WEST SUSSEX COUNTY COUNCIL CONSULTATION

TO:	Arun District Council FAO: Amber Willard
FROM:	WSCC – Highways Authority
DATE:	1 May 2025
LOCATION:	Land adjacent to 1 Elm Cottage Hook Lane Aldingbourne PO20 3TG
SUBJECT:	AL/30/25/OUT Outline application with some matters reserved (except access) for 2 No dwellings served from a new access in the location of the existing access. This application is a Departure from the Development Plan.
DATE OF SITE VISIT:	1 May 2025
RECOMMENDATION:	Advice

Drawing No. **2024-6645-004** Rev. **B**

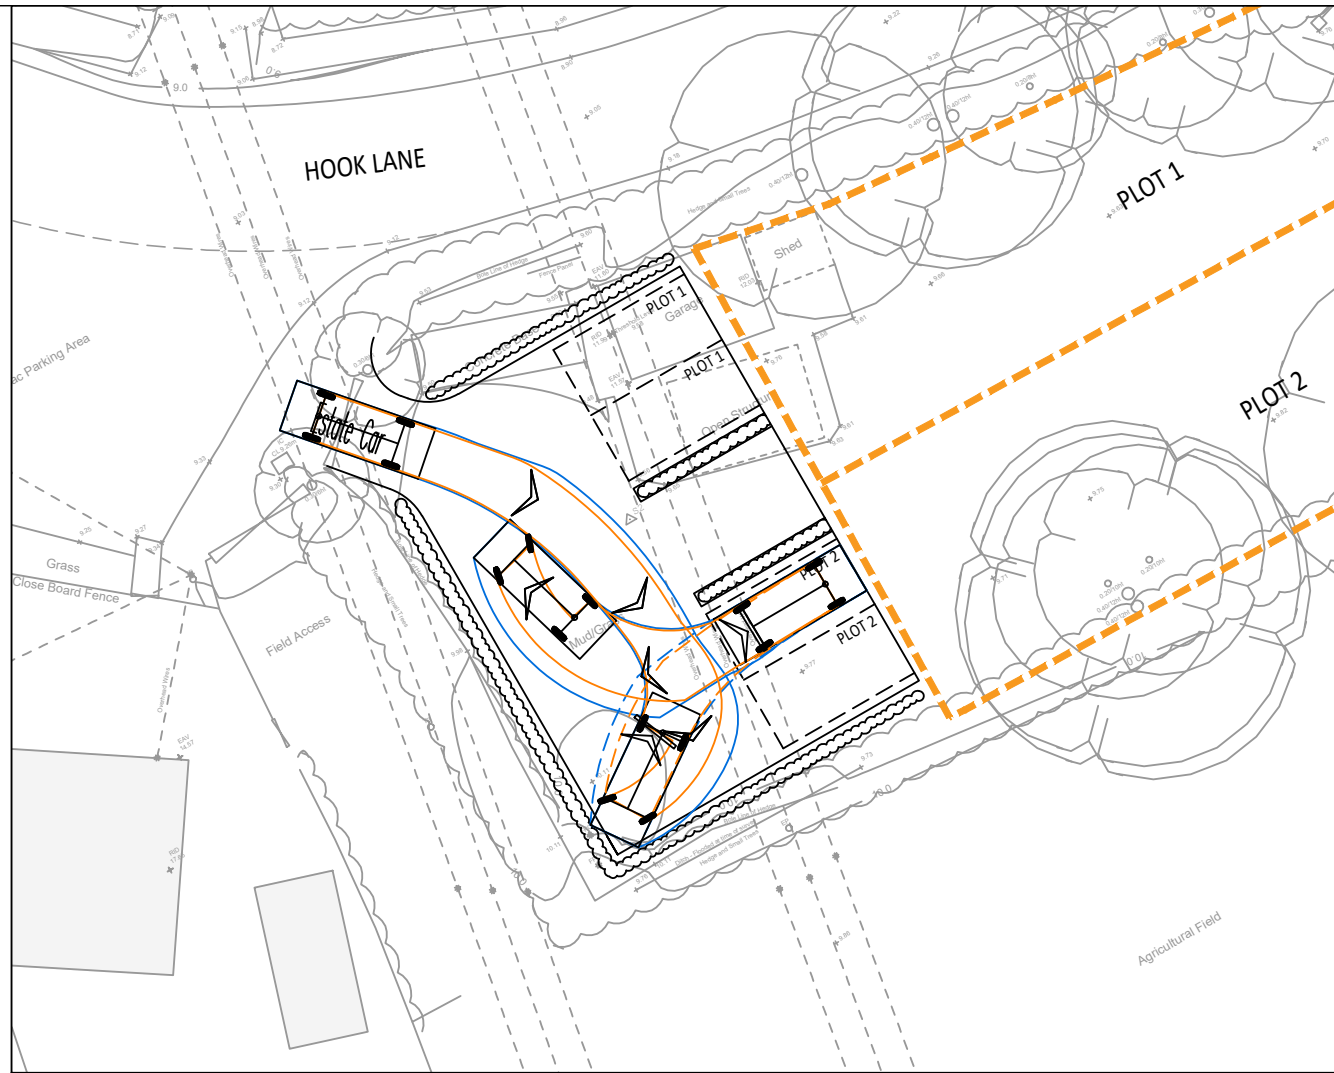
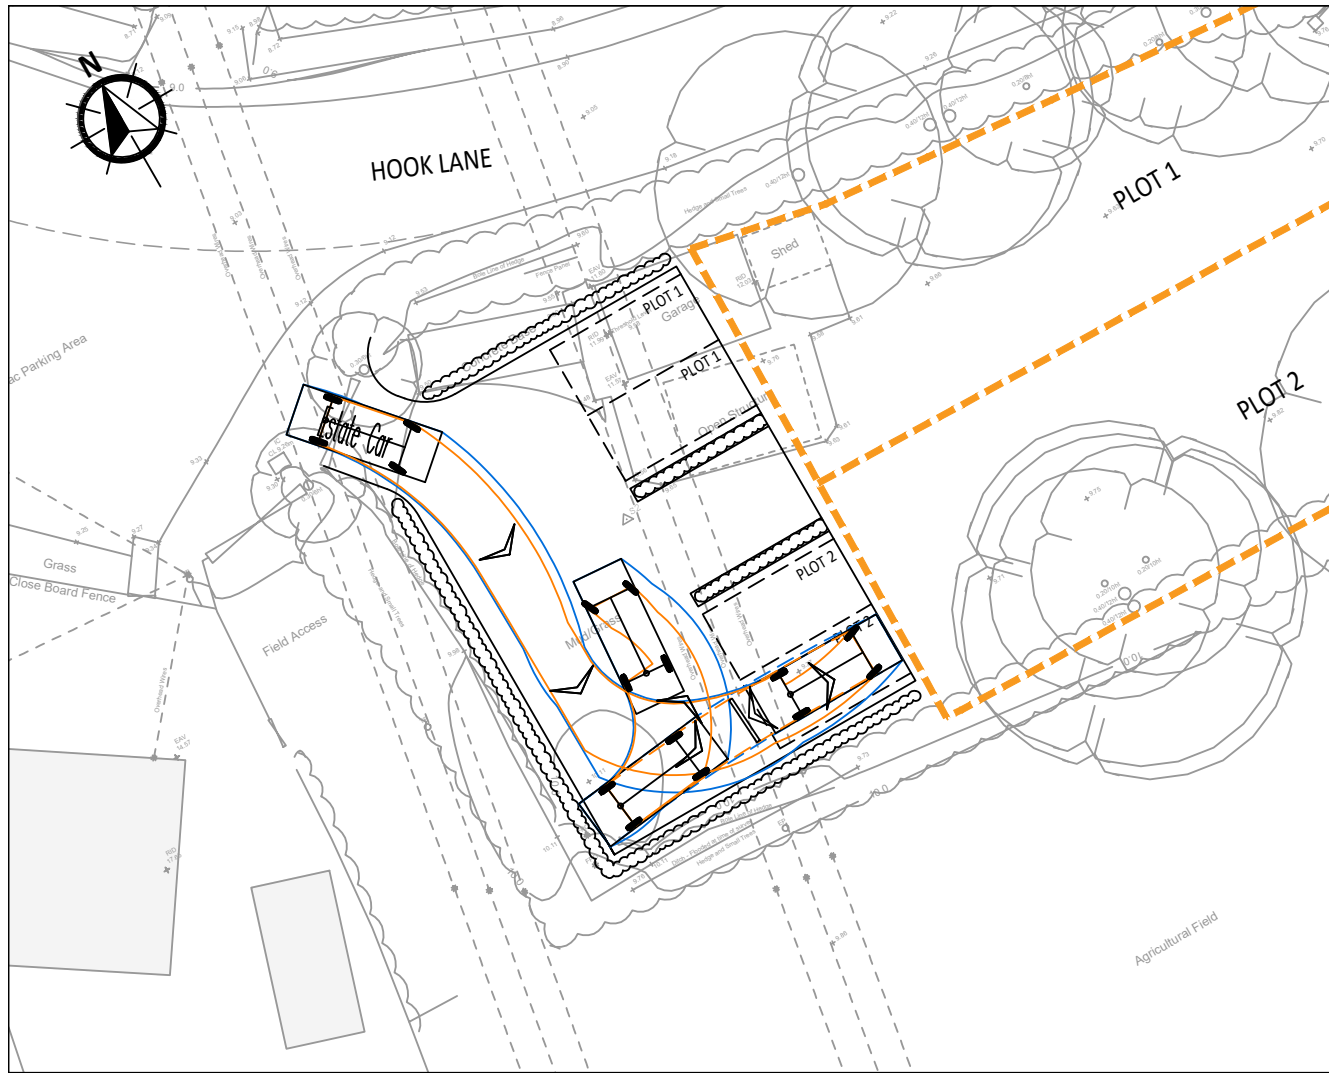
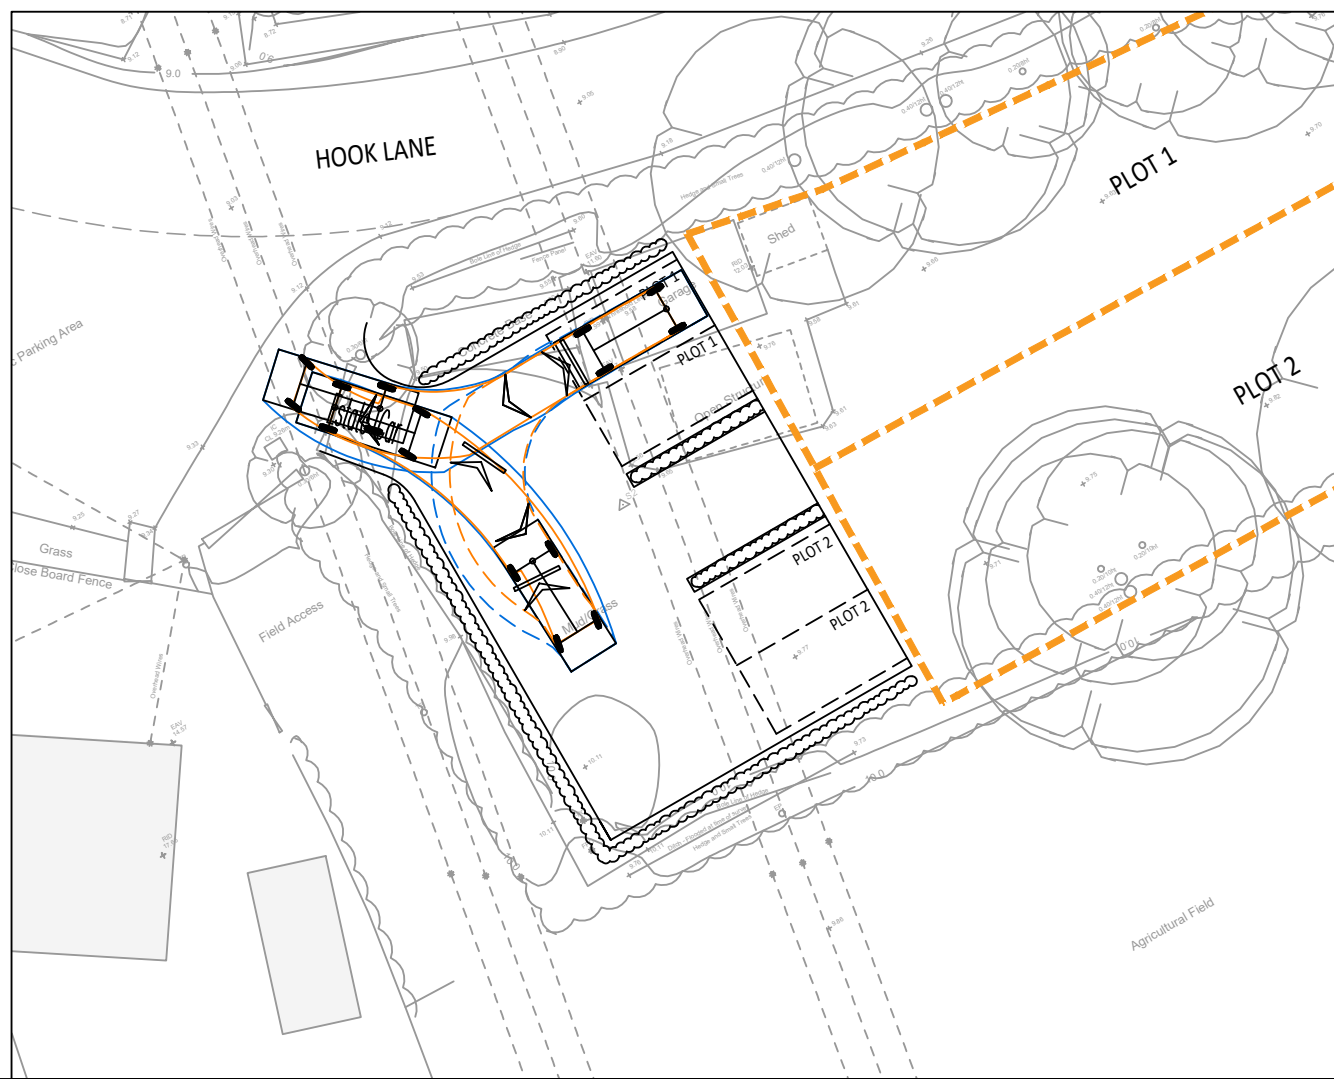
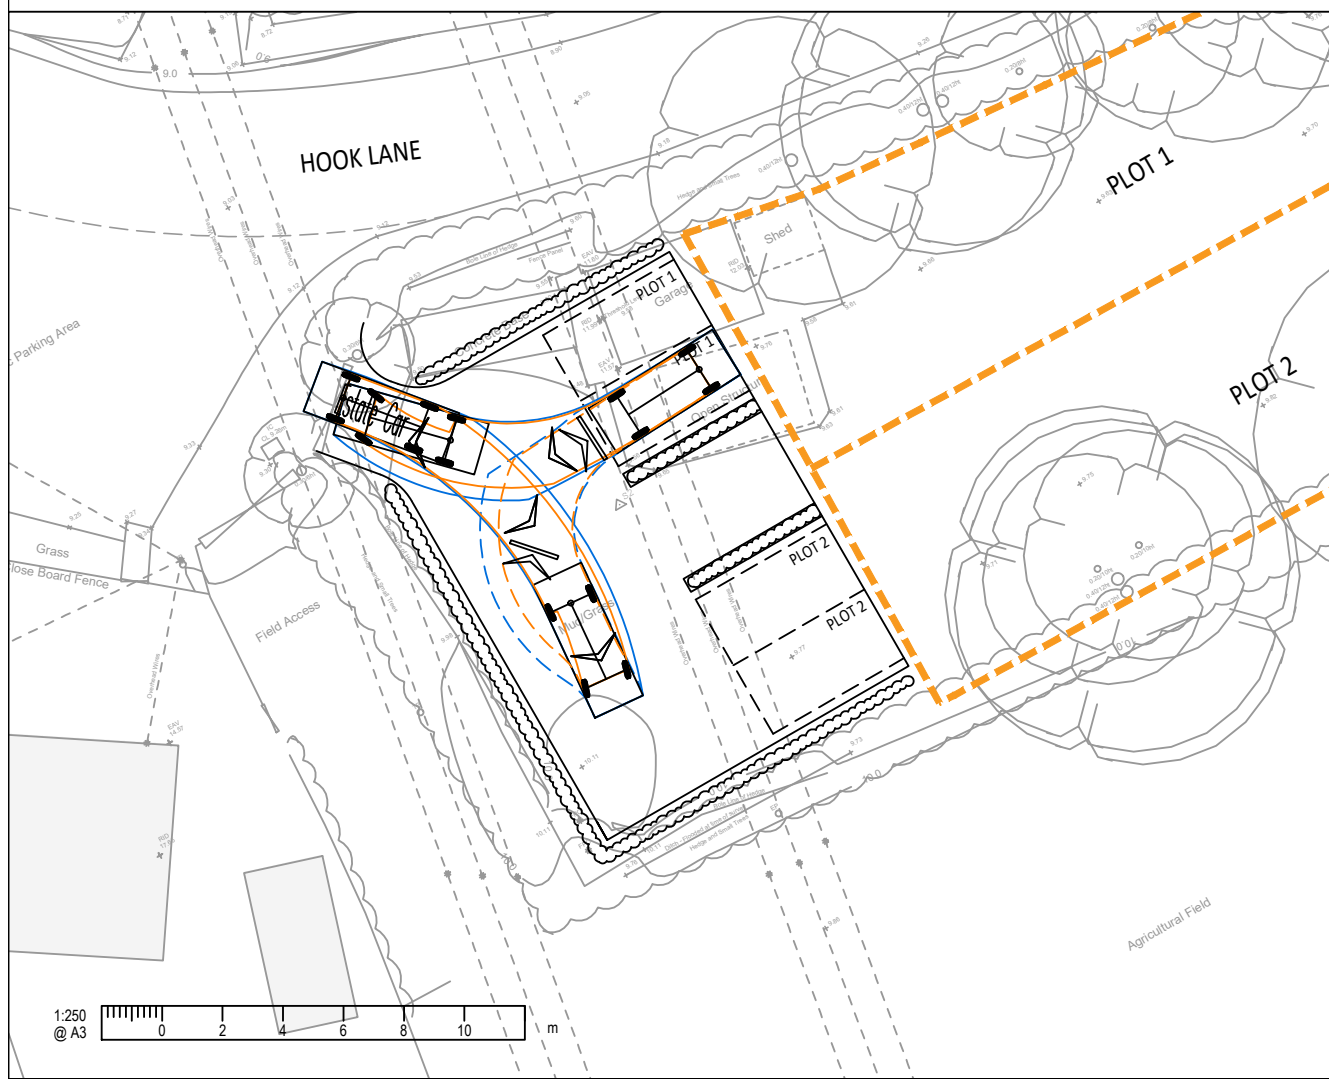
The current parking plan shows that two parking spaces would be assigned to each property to serve 3 to 4 bedroom dwellings. The Application Form however outlines that the dwellings would contain 4+ bedrooms each. Within the Arun Parking Standards, it is outlined that dwellings of 4+ bedrooms will require 3 parking spaces. The applicant may wish to take this into consideration prior to seeking the reserved matters for layout and parking. Cycle parking should also be demonstrated within future parking plans.

All parking space dimensions must be in line with WSCC standards and retain the turn on site functionality.
